Phone: 0300 123 6780
Email: Kathryn.Walsh@lancashire.gov.uk
Your ref: 3/2024/0187
Our ref: 3/2024/0187/HDC/KW
Date: 09 October 2024

Location: Clayton Manor Ribchester Road Wilpshire BB1 9HU
Proposal: Proposed construction of four one-bedroom apartments in a purpose-built detached building with access off Ribchester Road, following demolition of existing garage. Resubmission of 3/2023/0930.
Grid Ref: 368478 432571

Dwg. no	Revision
2101 - 02	A

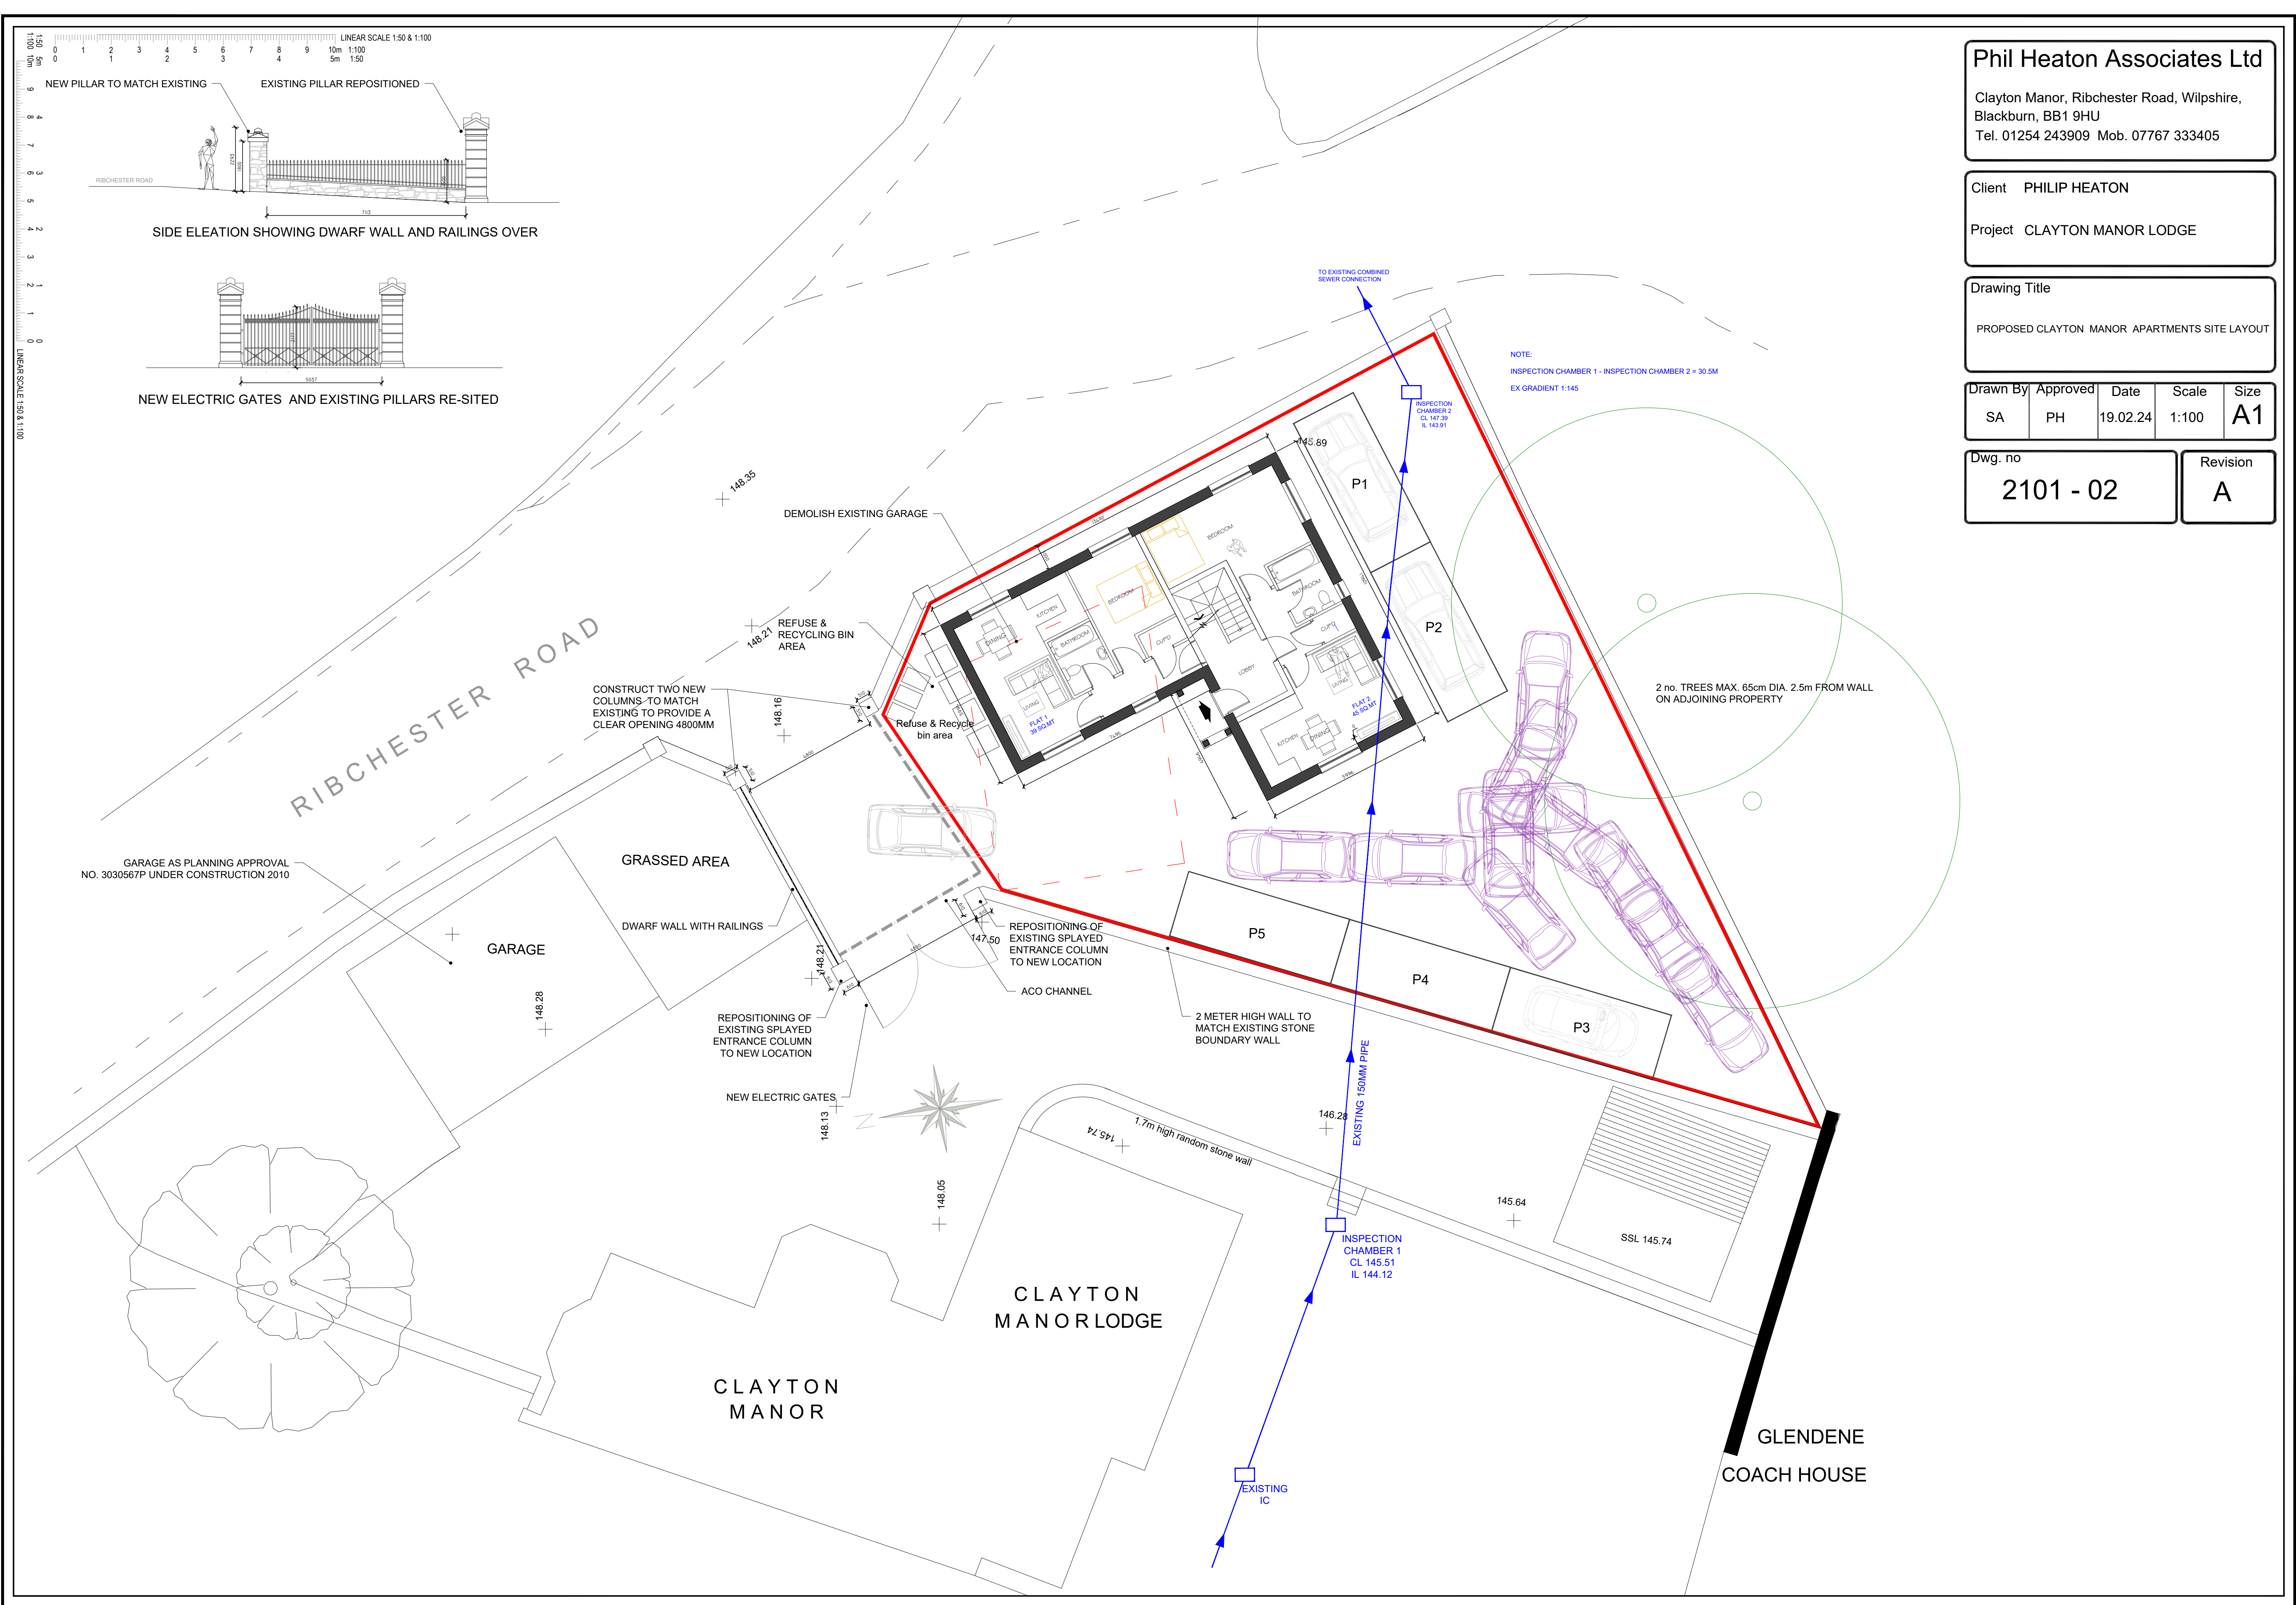
The amended site plan, drawing 2101 – 02 Rev A, shows that the proposed access is to be approximately 6m wide which is an acceptable width for the size and nature of the development. The existing vehicle crossing fronting the access on Ribchester Road shall be extended across the entire new width. The extended vehicle crossing within the adopted highway will need to be constructed under a section 171 agreement of the Highways Act 1980.

To overcome potential internal conflicts when large vehicles are using the internal access, as noted from drawing 2101 – 02 Rev A, the access has been widened until it reaches the gate serving Clayton Manor. This allows for two-way movements along the internal access track and there is more space for large vehicles to turn into and out of the site. The applicant has also provided evidence to show that turning within the site is possible to enable ingress and egress in a forward gear.

Before the widened access is used for vehicular purposes, the first 5m from the highway boundary into the site shall be appropriately paved in tarmacadam, concrete, block pavements, or other hard material to prevent debris from being dragged onto the highway.

2. No part of the development hereby permitted shall be occupied until such time as the access arrangements shown on drawing number 2101 – 02 Rev A have been implemented in full.
